Environmental Health Consultation Response	Officer	Alan Taylor
---	----------------	--------------------

Address:	Clithroe road Clitheroe BB7 1PT			 <p>Ribble Valley Borough Council www.ribblevalley.gov.uk</p>
Application Ref:	37491	Case Officer:	Adam Birkett	
Response Ref:	/ENV/01	Issue Date:	3 October 2017

General Comments/Observations	
1.1	There are several separate applications for the Pendleton Hall Farm consisting of robotic milking shed/Left wing cow kennels/right wing cow kennels/Central tractor passage/earth backed slurry lagoon. This response will cover all applications.
Suggestions/Mitigation

Title: Proposed Plans and Elevations, Existing and Proposed Site Plans.

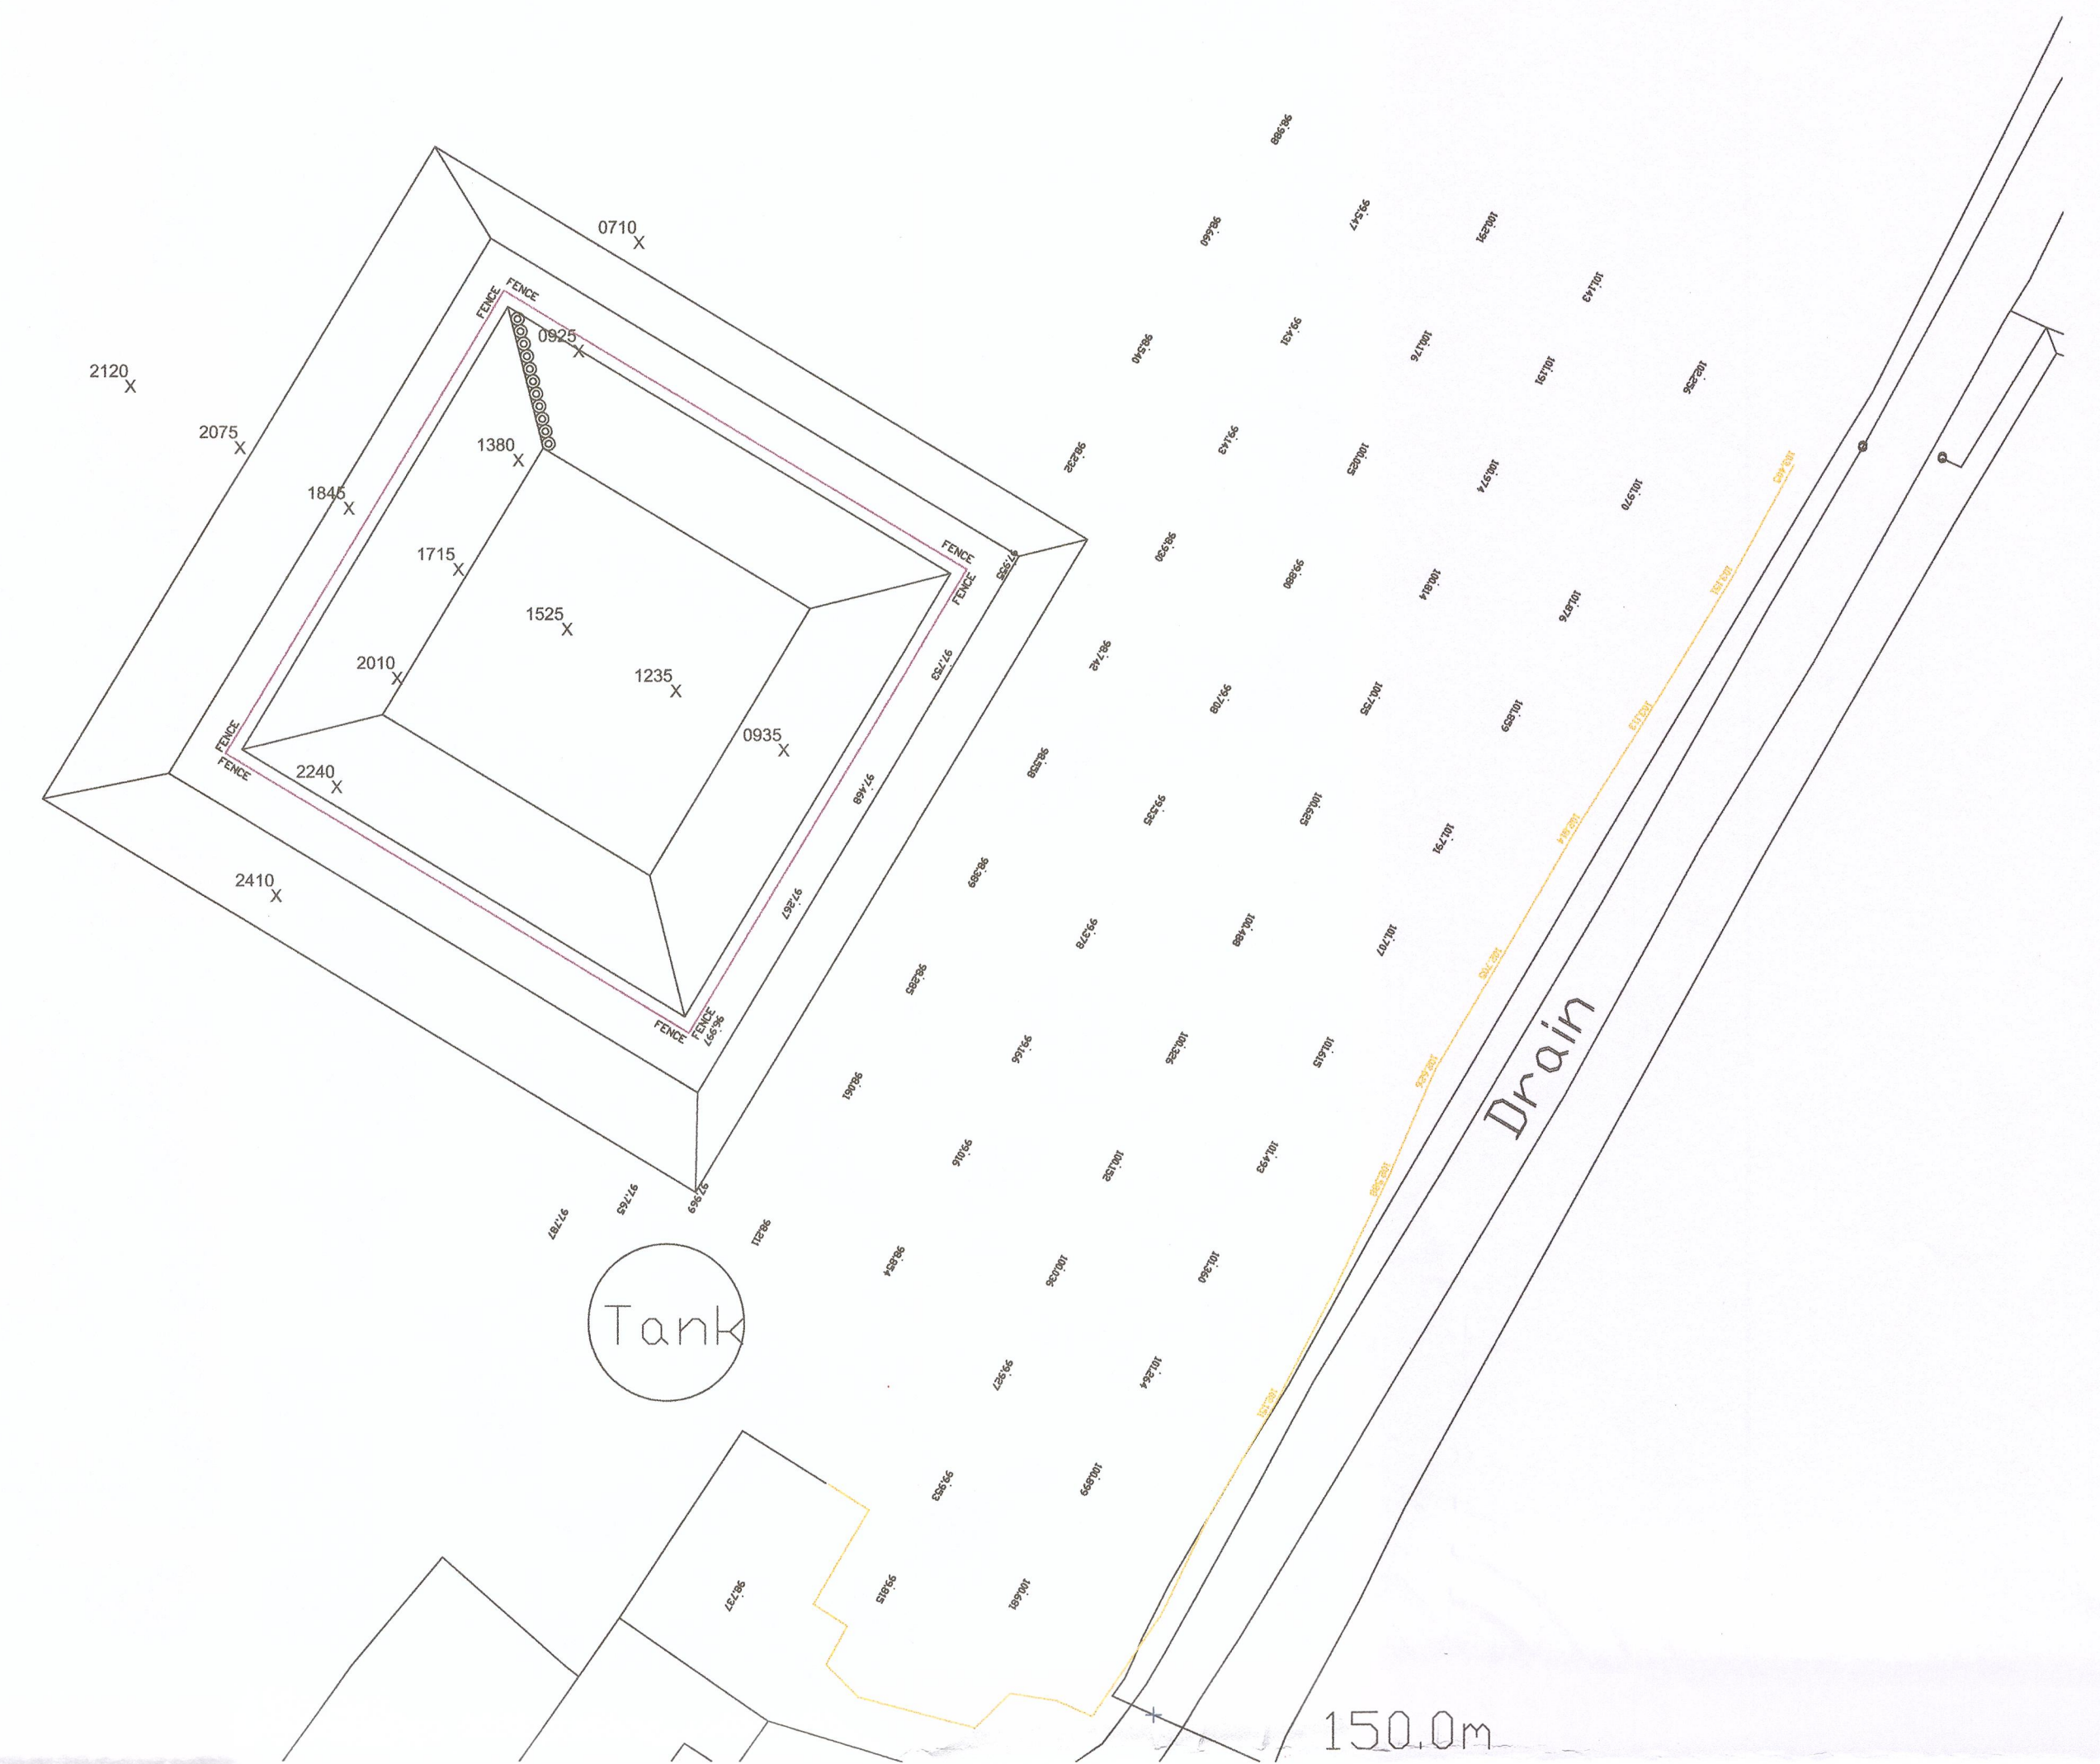
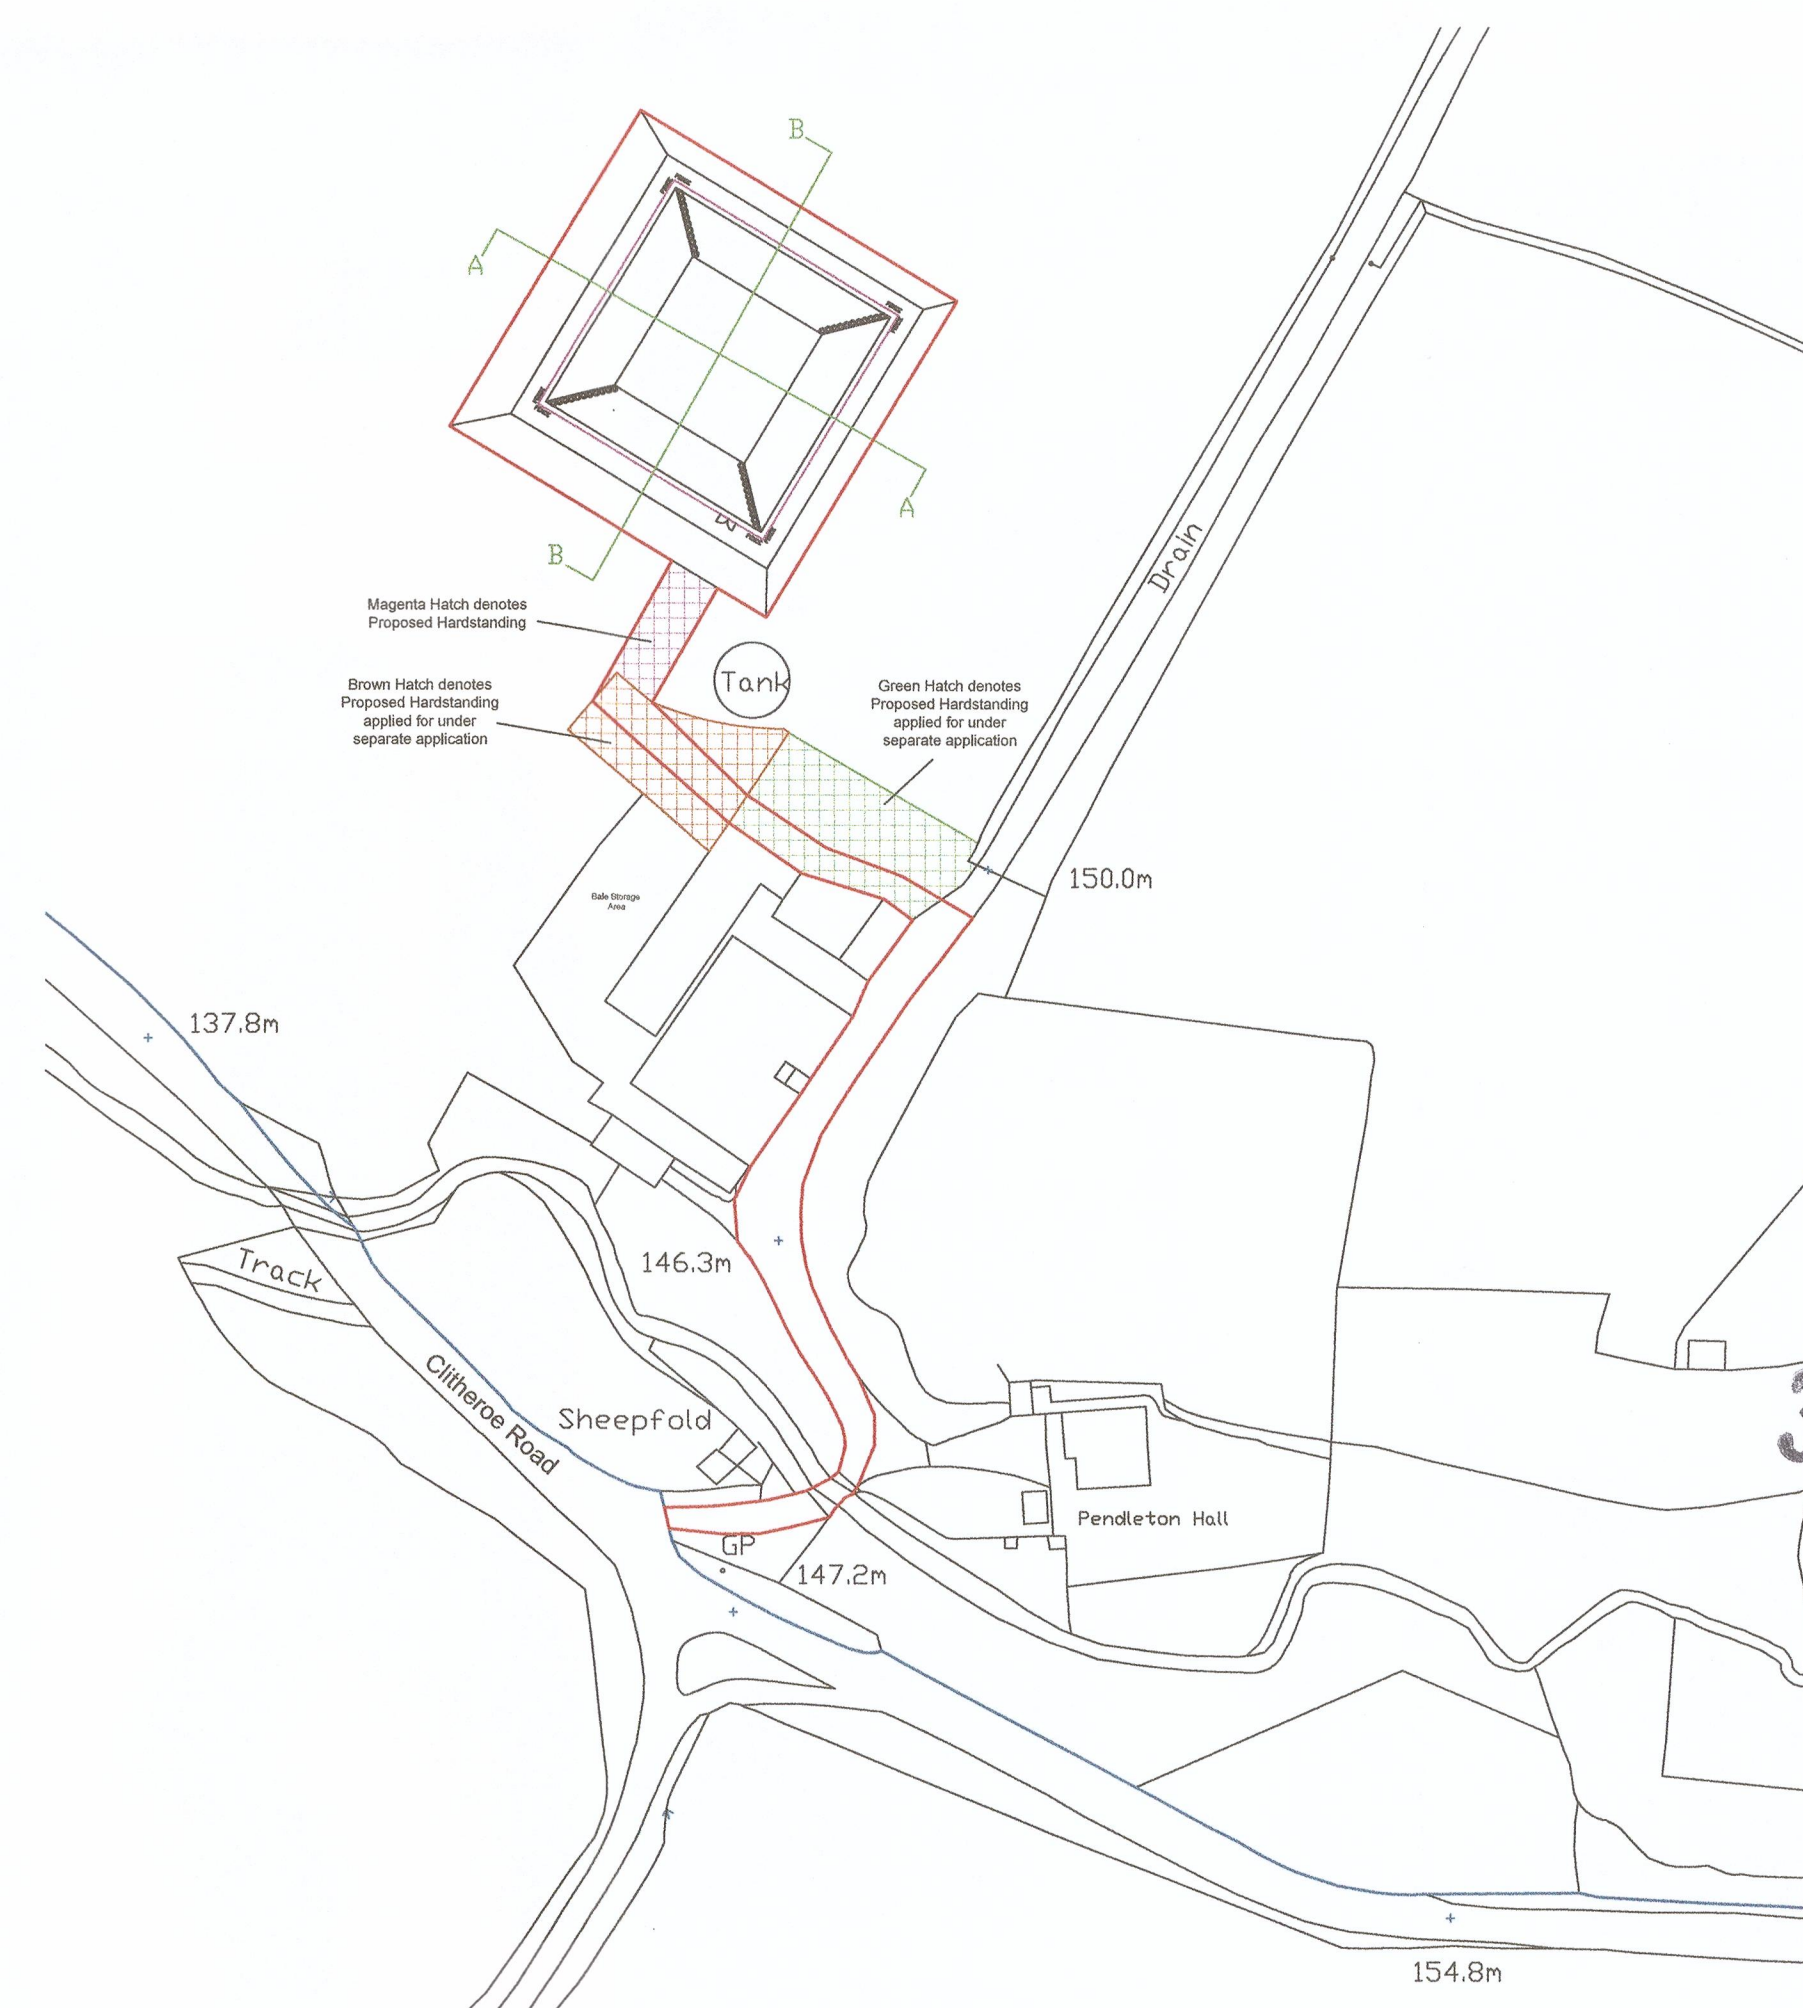
2.1	The planned development of the milking shed, cow kennels, and central passage for the tractor do not raise concern or require any changes to the planned development. The Slurry lagoon development requires extensive earth movement to produce containment for 4000m ³ .
Conclusions/Suggested Conditions

2.3	Should you be minded to approve the application, notwithstanding other considerations, I would suggest that the following conditions be attached should you feel they are relevant and justified: <ul style="list-style-type: none"> The construction of the lagoon must be as per the Environment Agency guidelines which is to be impermeable to prevent any run-off or leakage of slurry to surround land or water courses.
	Officer: Alan Taylor
